FP/135/25/PL

The Fox Inn Waterloo Road Felpham PO22 7EH

Change of use of first floor to provide 5 No. guest bedrooms with ensembles for short term stays, replacement timber pergola and replacement first floor windows.

## The Fox (Amended designs in white)

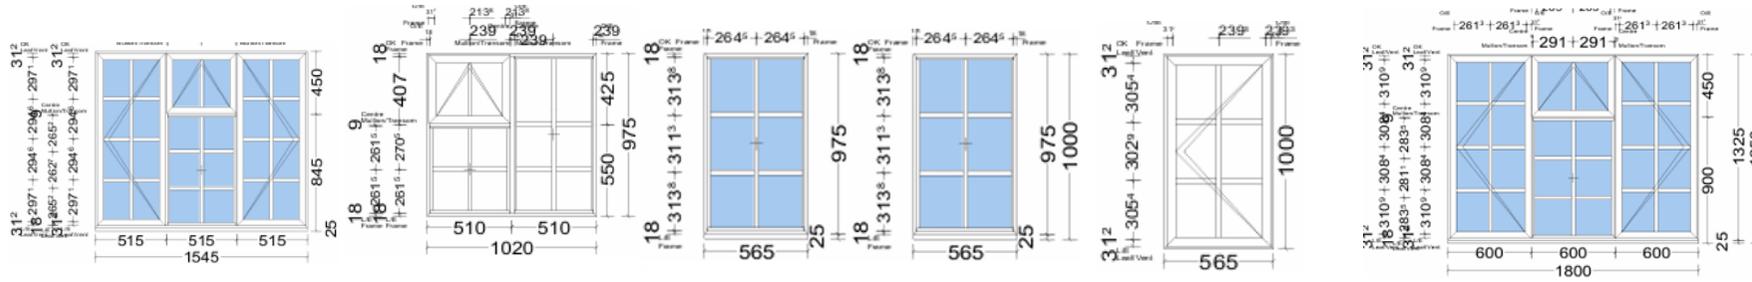
I have reviewed the plans and consider that the revised plans which show the retention of the existing bay window is positive. My other comments remain.
